Application number: 2024/93046	
What is the application for?:	Outline application (access, layout, scale, appearance) for demolition of stable
Address of the site or building:	land at, Mount Pleasant, Plains Lane, Marsden, Huddersfield, HD7 6AN
Postcode:

User comments

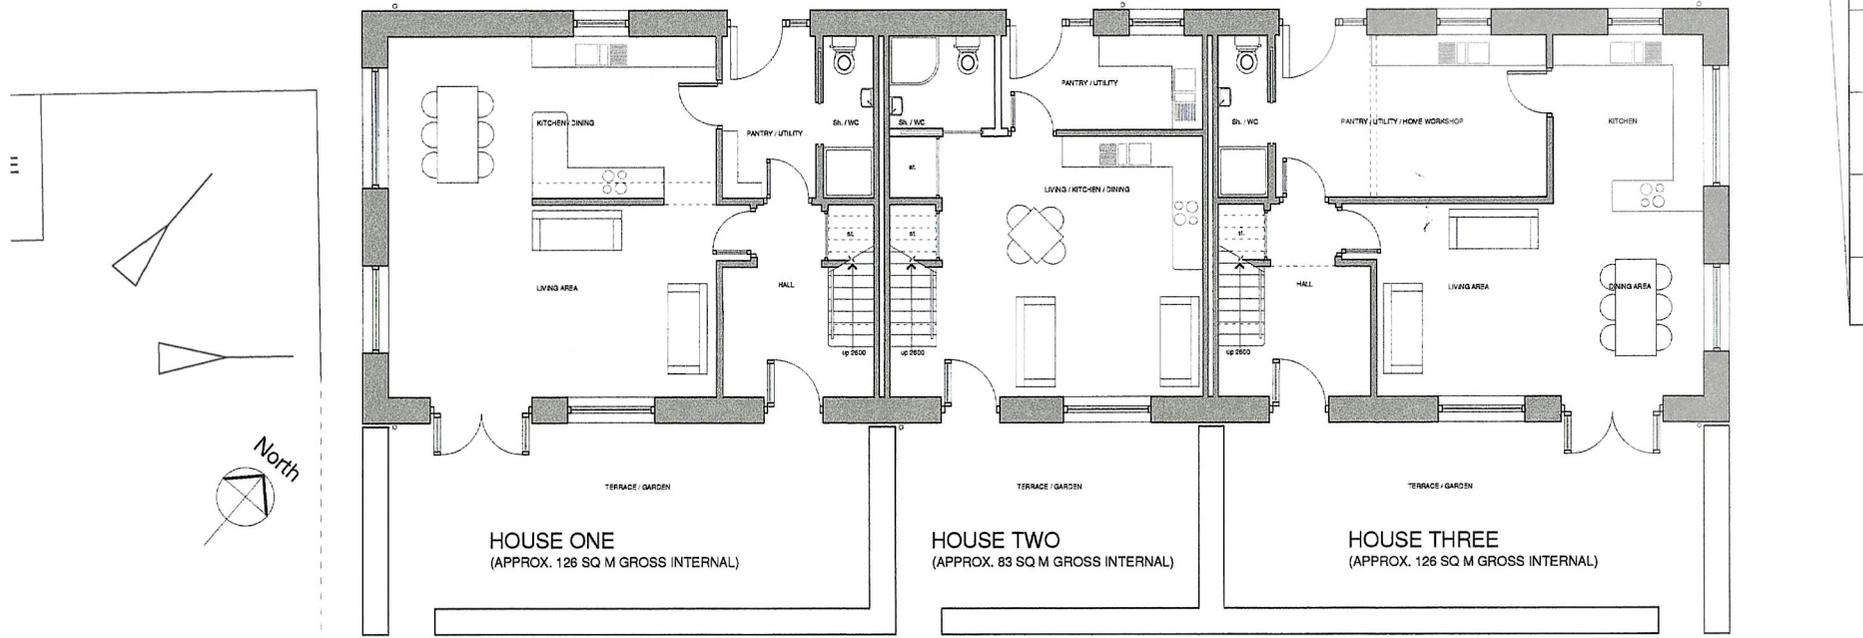
5. One very minor point about the plans as submitted is the bedroom skylights
We merely make the observation that may be able to see into those windows given the elevation from house and gardens.

SITE PLAN

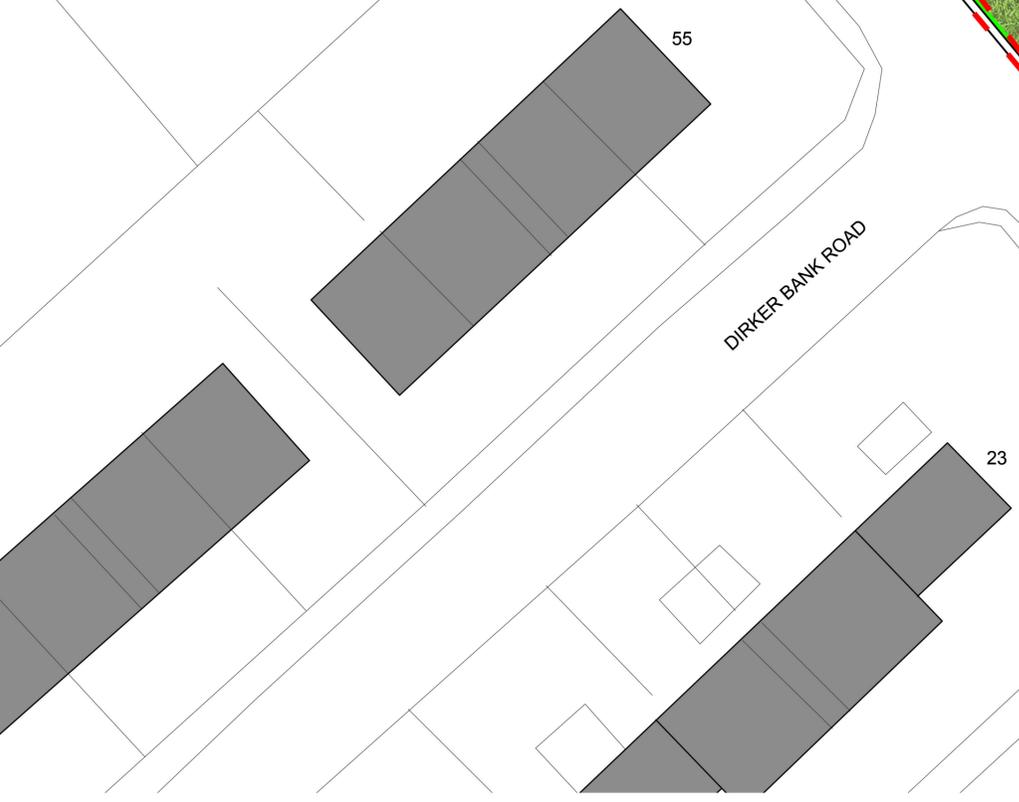
4. One concern is that the proposed allotments whilst they are aimed at creating a public good and we would support the orderly generation of the plot, there are concerns that structures beyond those in the present plan (a polytunnel and composting toilet) could be erected which would alter the character of the plot.

We do not object to the proposed use as a community garden but in order to alleviate concerns about future development, there should be removal of exiting permitted development rights for the upper field (not the lower plot where the houses are proposed) so that planning would be required in respect of structures beyond those within the existing plans. This would alleviate concerns about future development of the upper part of the site.
